From: Tim Townsend [REDACTED]
Sent: 27 November 2018 11:31
To: Claire Potts
Cc: Planning.Responses; Derek Whittington; Elaine Munns; Eloise Short
Subject: AL/118/18/OUT - Outline application for construction of 10 homes - Ryefields Farmhouse, Oak Tree Lane, Woodgate, PO20 3GU - WSCC Highways response dated 27th November 2018

WEST SUSSEX COUNTY COUNCIL CONSULTATION

TO:	Arun District Council FAO: Claire Potts
FROM:	Highways, WSCC: Tim Townsend
DATE:	27 th November 2018
LOCATION:	Ryefields Farmhouse, Oak Tree Lane, Woodgate, Chichester, PO20 3GU
SUBJECT:	AL/118/18/OUT Outline application with some matters reserved for the demolition of existing buildings & the erection of 10 No. dwellings comprising 1 No. three bedroom detached, 2 No. three bedroom semi detached, 4 No. four bedroom semi detached & 3 No. four bedroom detached houses with associated access & parking.
DATE OF SITE VISIT:	
RECOMMENDATION:	☒ Advice ☐ Objection ☐ Modification ☐ No Objection ☒ More Information ☐ Refusal
S106 CONTRIBUTION TOTAL:	£7,130 per-dwelling contribution towards highways infrastructure to support the BEW Strategic Allocation. Non-highways found at foot of this report.

Rev A 30.01.2019
Access amended and grasscrete area added
Verge cut back; kerbline adjusted; bin
collection areas re-located.

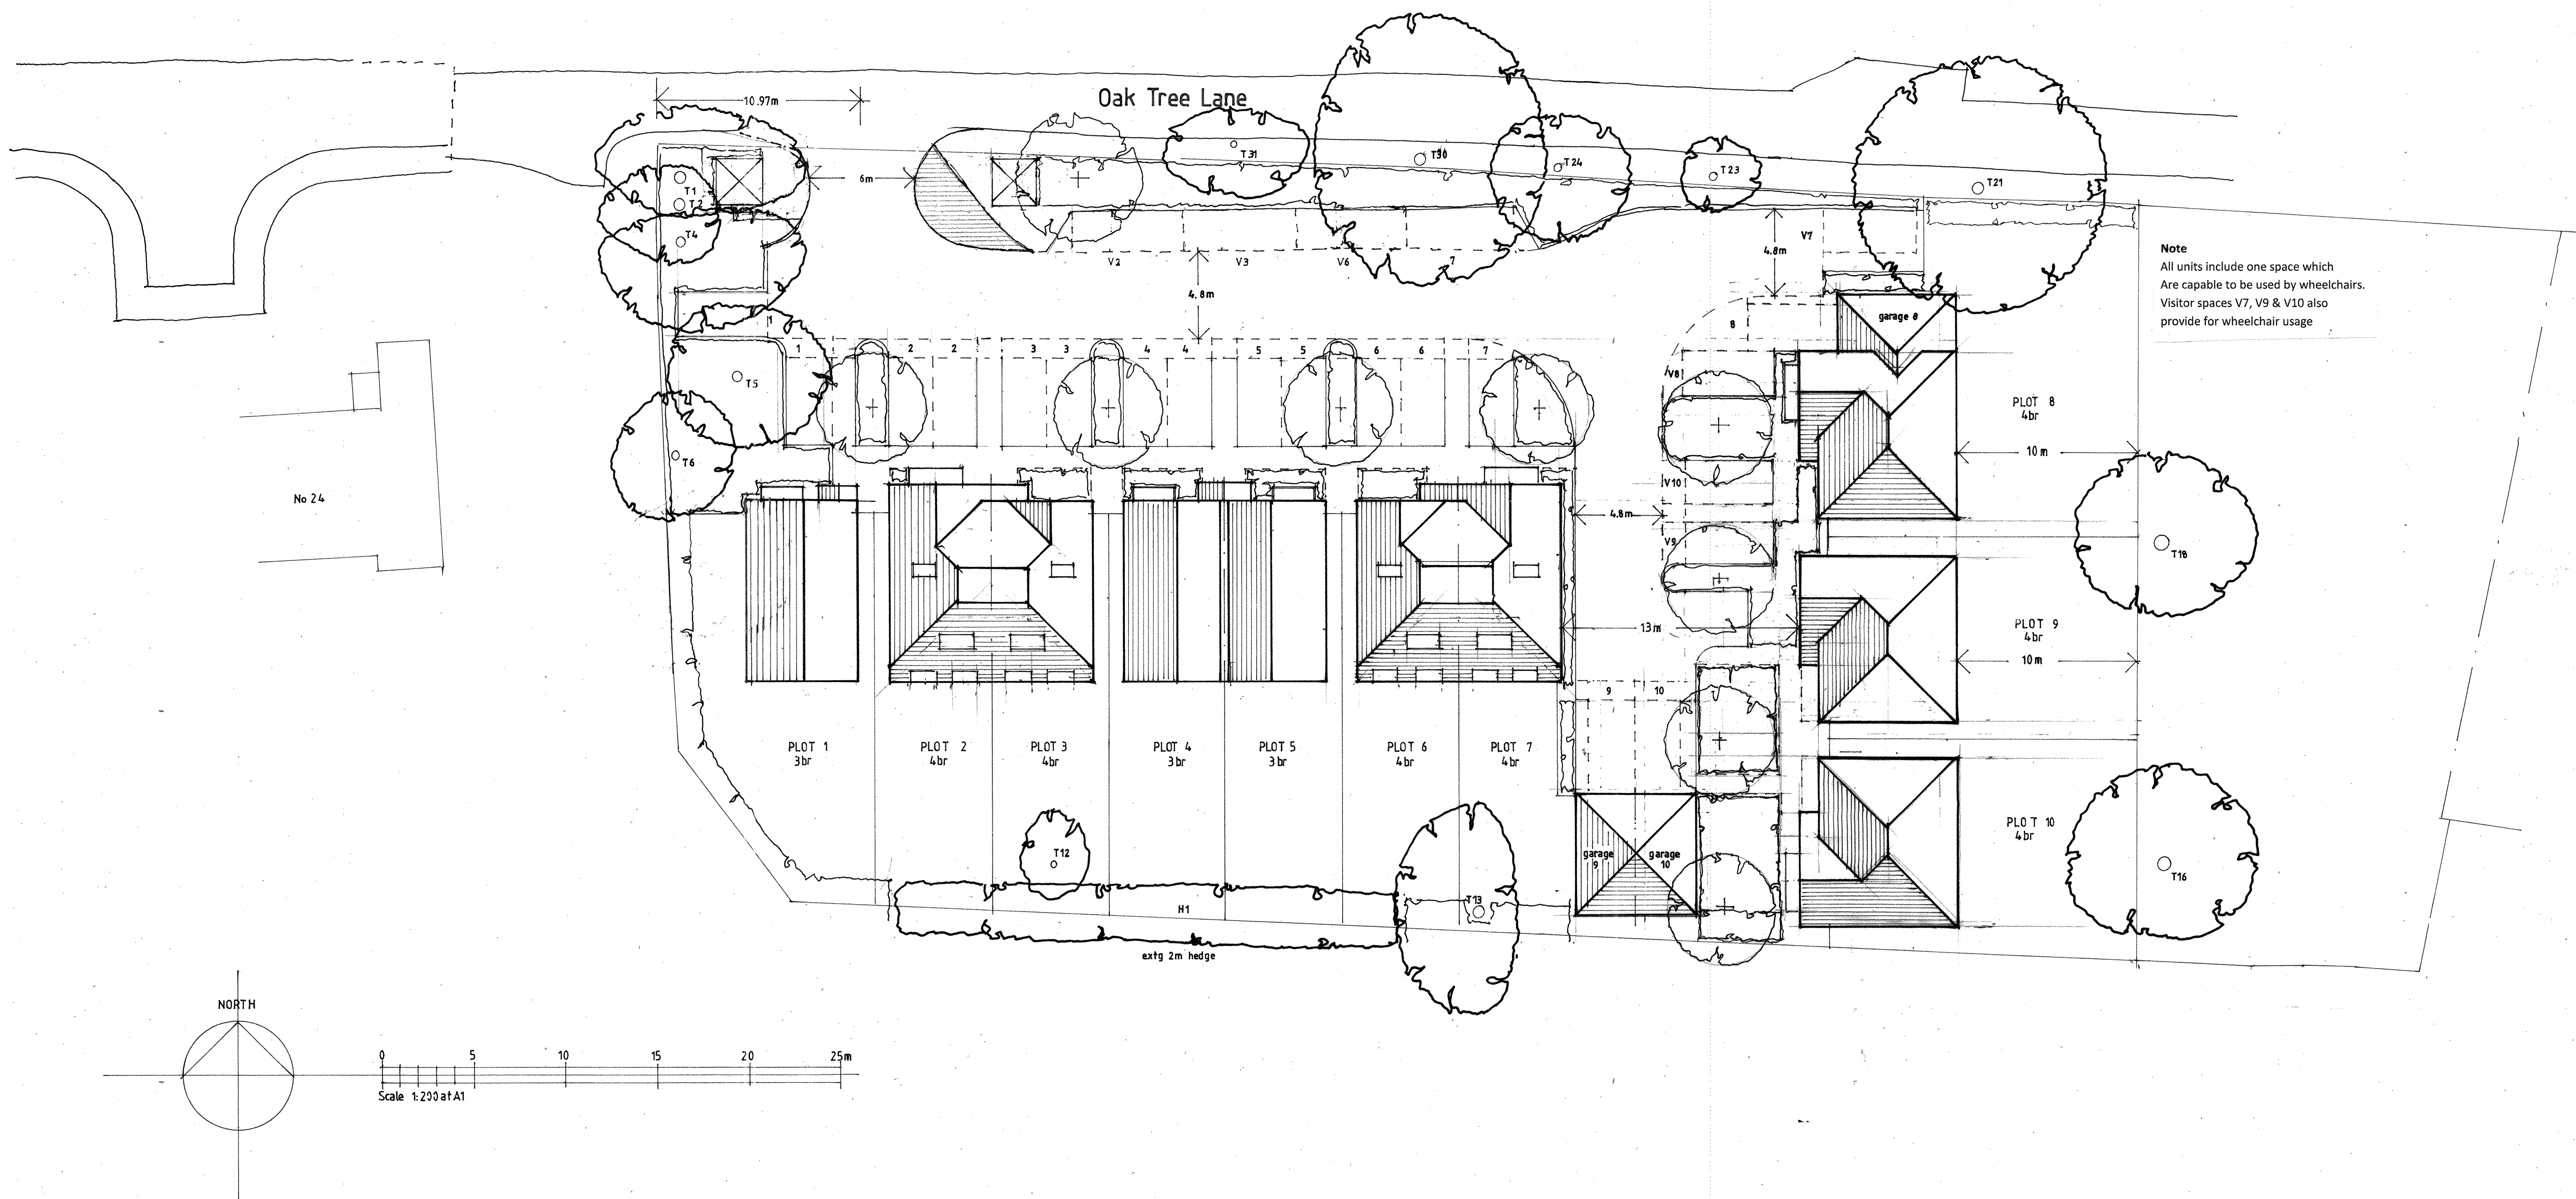
It is unclear from the submitted drawings whether the footway found in the existing residential part of Oak Tree Lane is to be extended to connect to the application site. Neither is it clear whether any street lighting is proposed. Given that the section of Oak Tree Lane where the site is proposed is narrower, more rural, unlit and provides access to a commercial development eastwards, the applicant is asked to show what measures are made for pedestrians entering and leaving the site. Also, the applicant should look to see whether it is possible to widen the first section of Oak Tree Lane from the existing residential development eastwards to provide for two-way movement of vehicles in the vicinity of the site entrance.

Further to this, no visibility splays are shown at the access point where it joins Oak Tree Lane. These should be shown in-line with guidance contained in Manual for Streets. Also, the proposed bin stores are likely to obstruct visibility either side of the access point and should be re-located clear of any sight line splays. Also, swept-path diagrams should be provided to demonstrate that both refuse and fire appliances can enter and leave the site and turn within it. The swept-path diagrams should also demonstrate that such vehicles will be able to negotiate the access itself, particularly as Oak Tree Lane narrows at the point the access is shown, potentially making it more difficult for vehicles to turn in or out. The applicant should also provide details of proposed access road surfacing – both in and out of the site.

1. Further consideration of pedestrian access into site.
2. Further consideration of widening first section of Oak Tree Lane (from existing residential part of the lane to - and including – the site access).
3. Visibility splays at the access point to the site (and bin stores moved clear of them).
4. Information about street lighting for Oak Tree Lane and the development site.
5. Swept-path diagrams demonstrating access to-and-from the site through the site access and also demonstrating the ability to turn within the site for fire appliances and refuse vehicles.
6. Information and plan showing how this site connects with the wider BEW site.
7. Traffic information about the adjacent commercial development.
